This document forms part of Deadline 11 response from Northgate Farm. The Response is intended to address comments made by the Applicant in the Deadline 10 submission referenced by “7.34 Applicant’s Response to Deadline 9”

Table 1-4 – Mark Hawes

Figure 1 – DCO Application proposed PMA Route

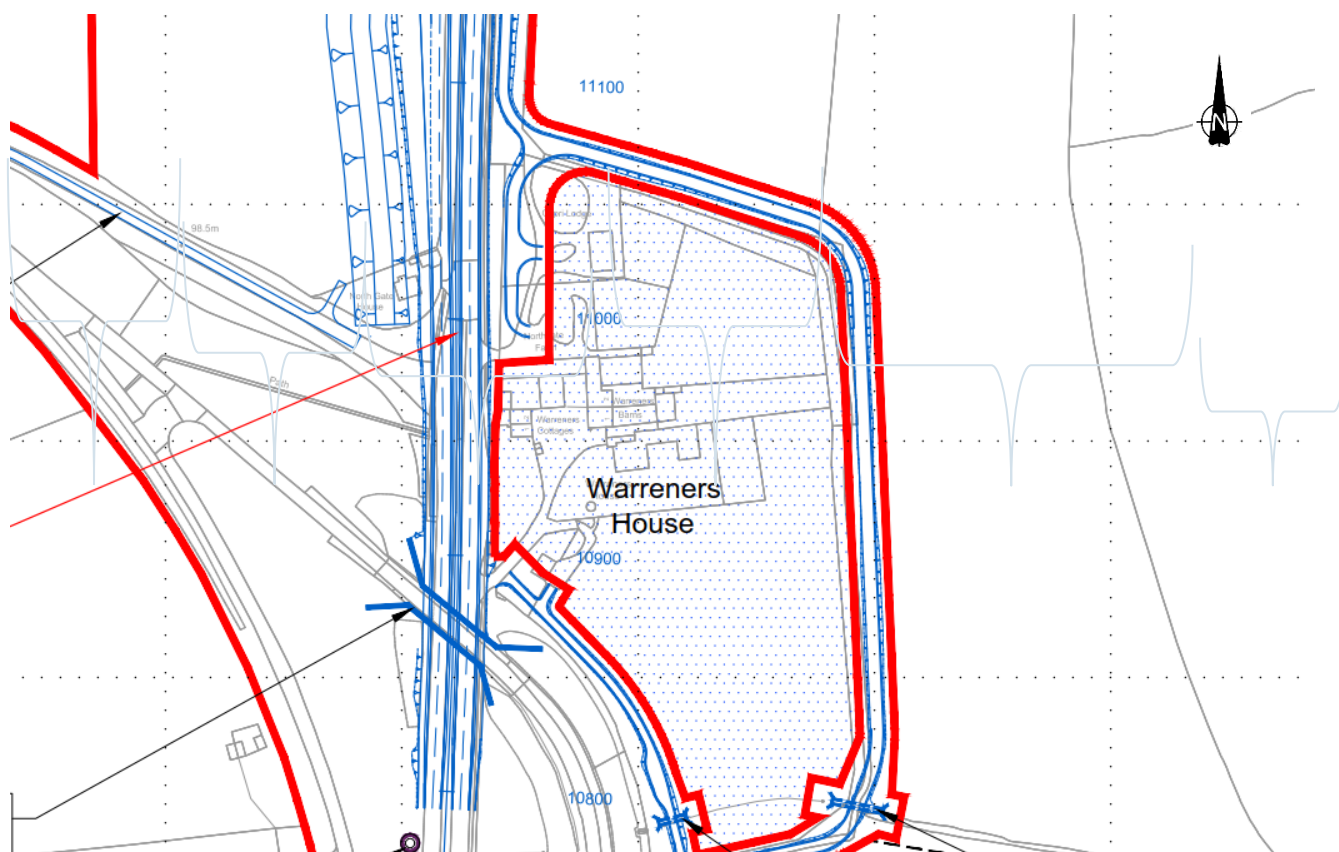
The original statement referenced the works that were required to facilitate the existing DCO access into the property within 1/8a. The references provided by the Applicant relate to the north east corner works within 1/8b which are out of context here.

The Applicant suggests that the existing DCO application remains viable. Given the previous communications with our neighbour we know that this is not true. It has been made clear that we will not be given unfettered access.

Figure 3 – Alternative Route B

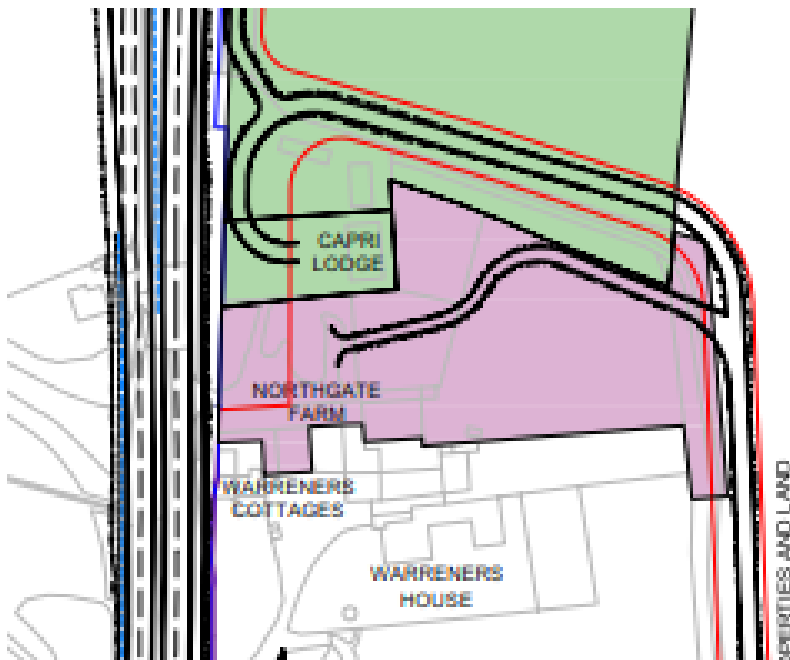
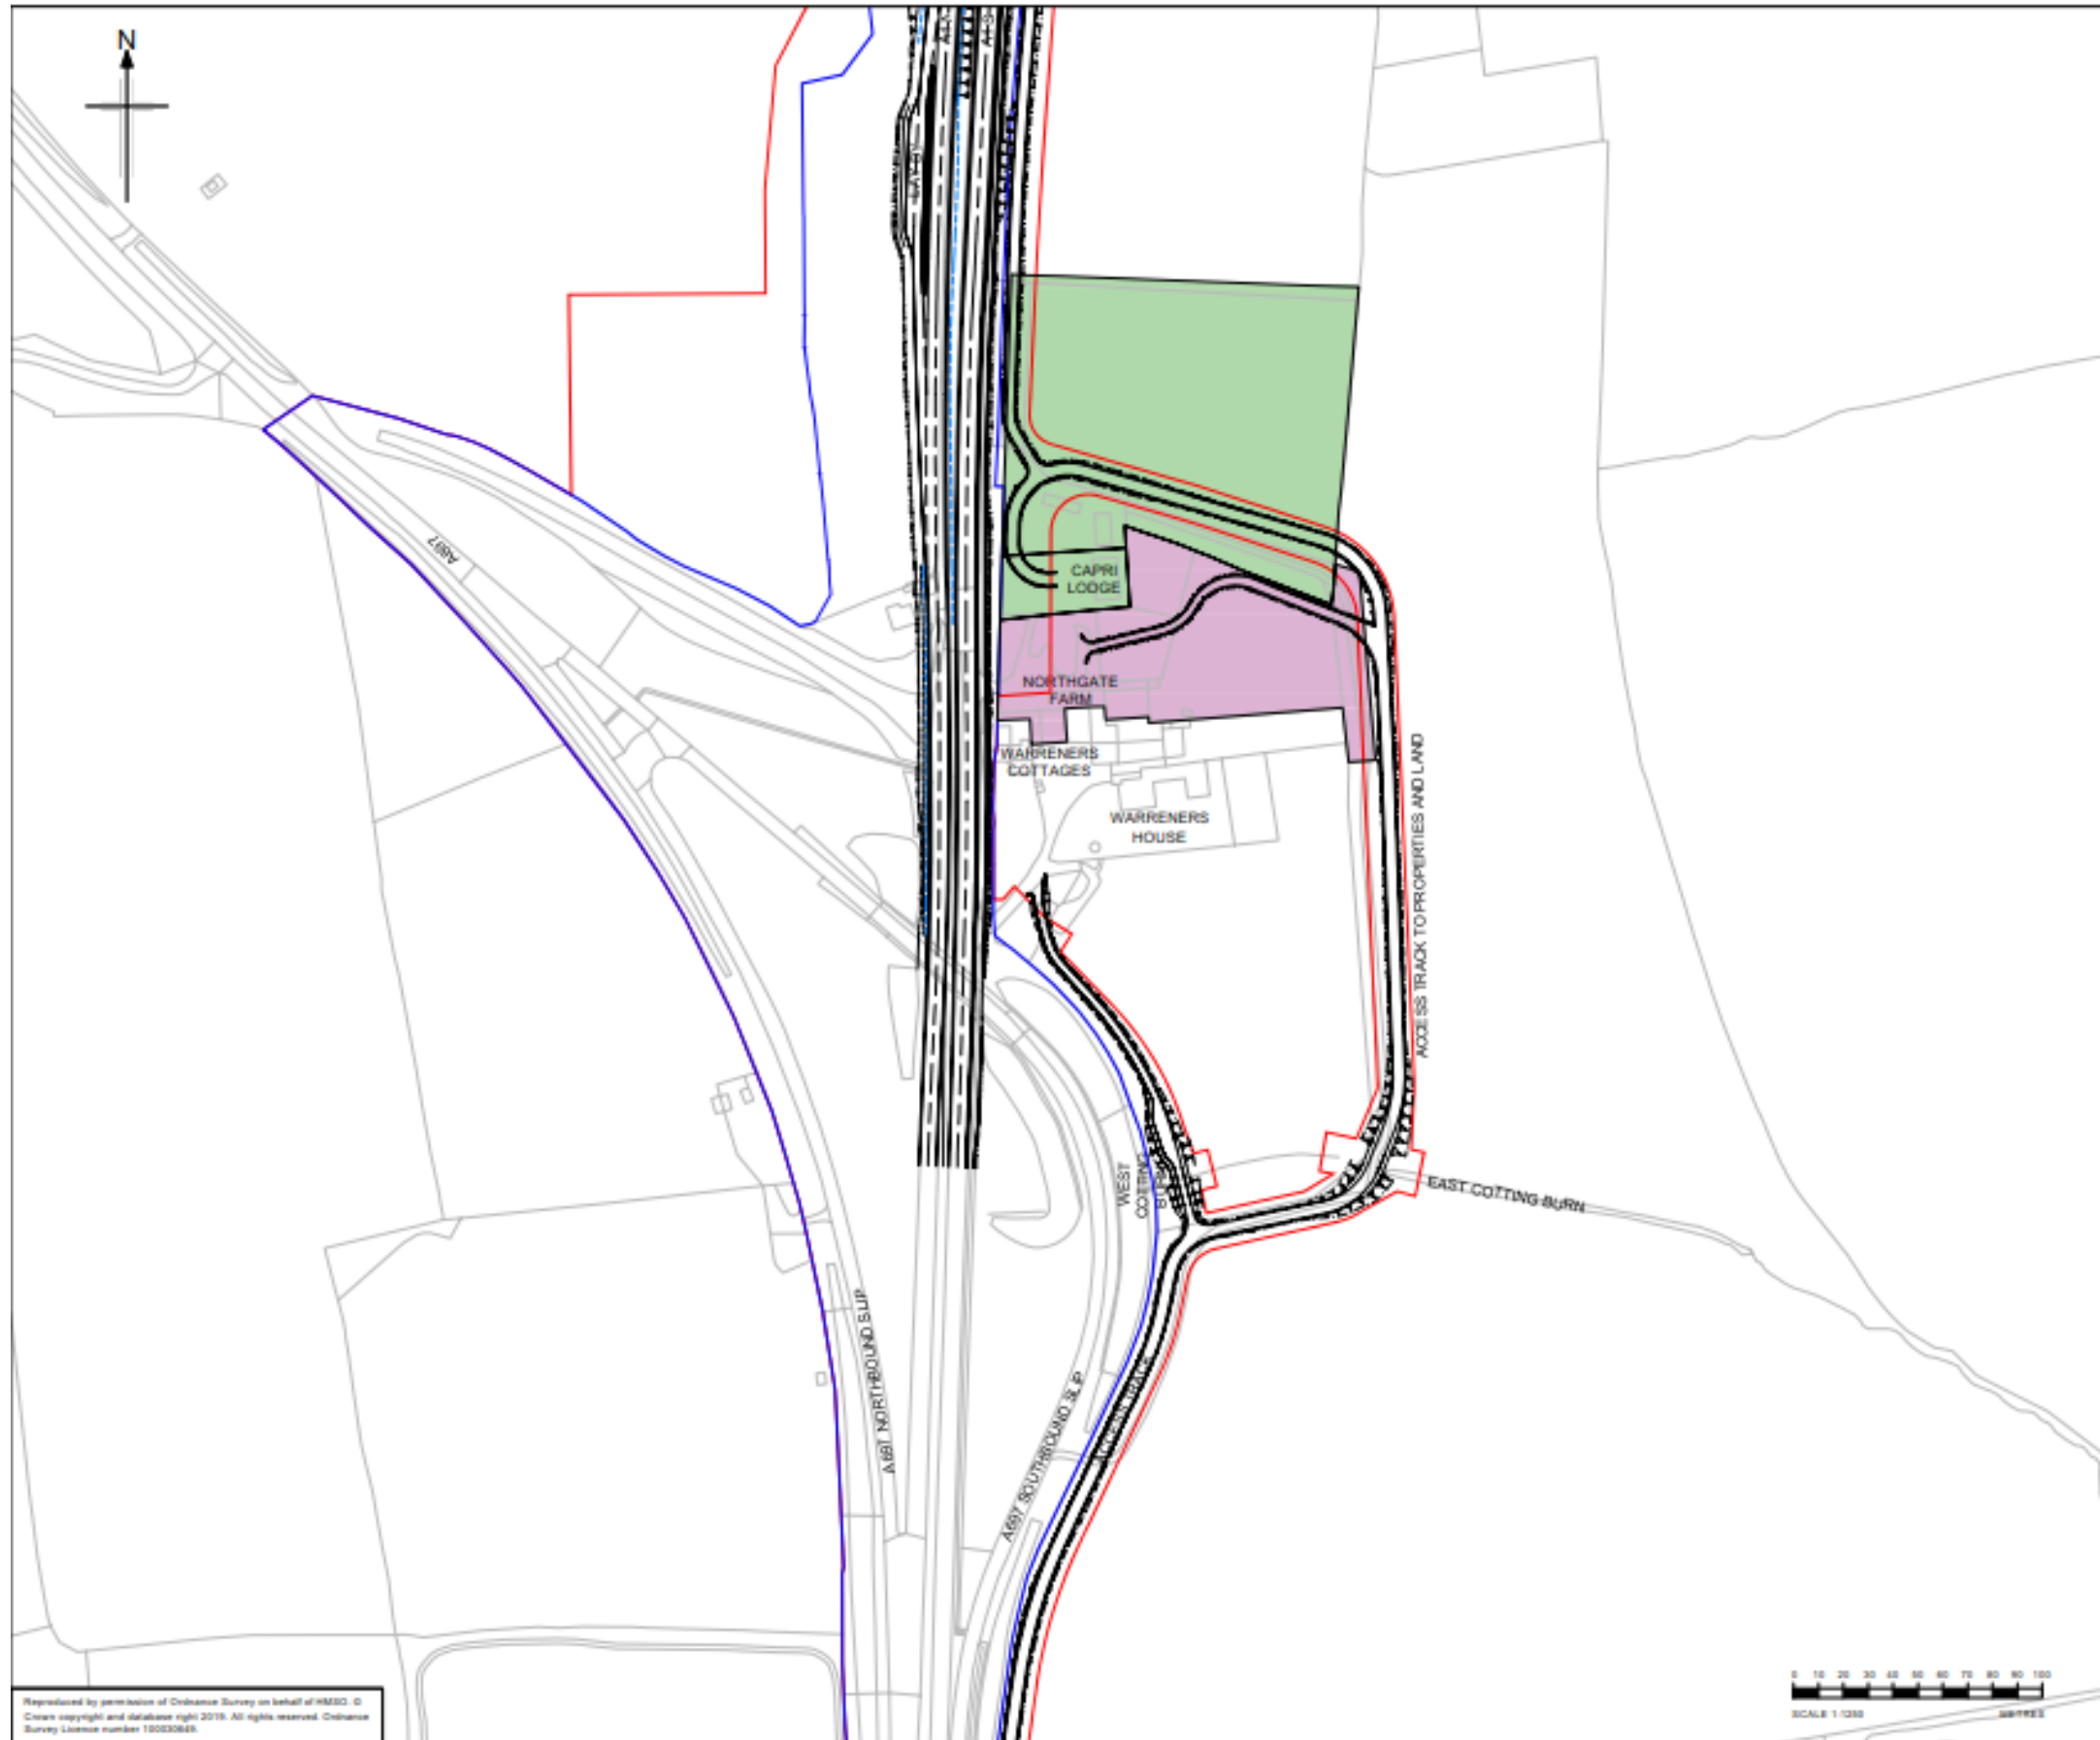
The response provided by the Applicant suggests that the length of the road for Alternative B is 120 meters. Given that the Applicant has already stated that they will not be responsible for determining the route within the property I am surprised that they are so confident of the length. In looking to protect key features in the garden and working around constraints we estimate this to be more like 135 metres at this stage (as measured on Google maps). The actual distance would ultimately be determined by a plan. In designing the road within the property additional attention and provision would need to be given to passing points and turning areas for large vehicles. This is not shown on the current illustration.

The applicant suggests that an additional PMA access road running through the centre of the garden would “not represent a major adverse effect on views from the dwelling, when considered in the context of the Scheme as a whole”. As highlighted previously within the visual effect agenda we are struggling to understand this conclusion given the clear visual impact of the road running directly through the centre of the garden of the property. Not forgetting that the following roads will also be visible from the dwelling in the future:
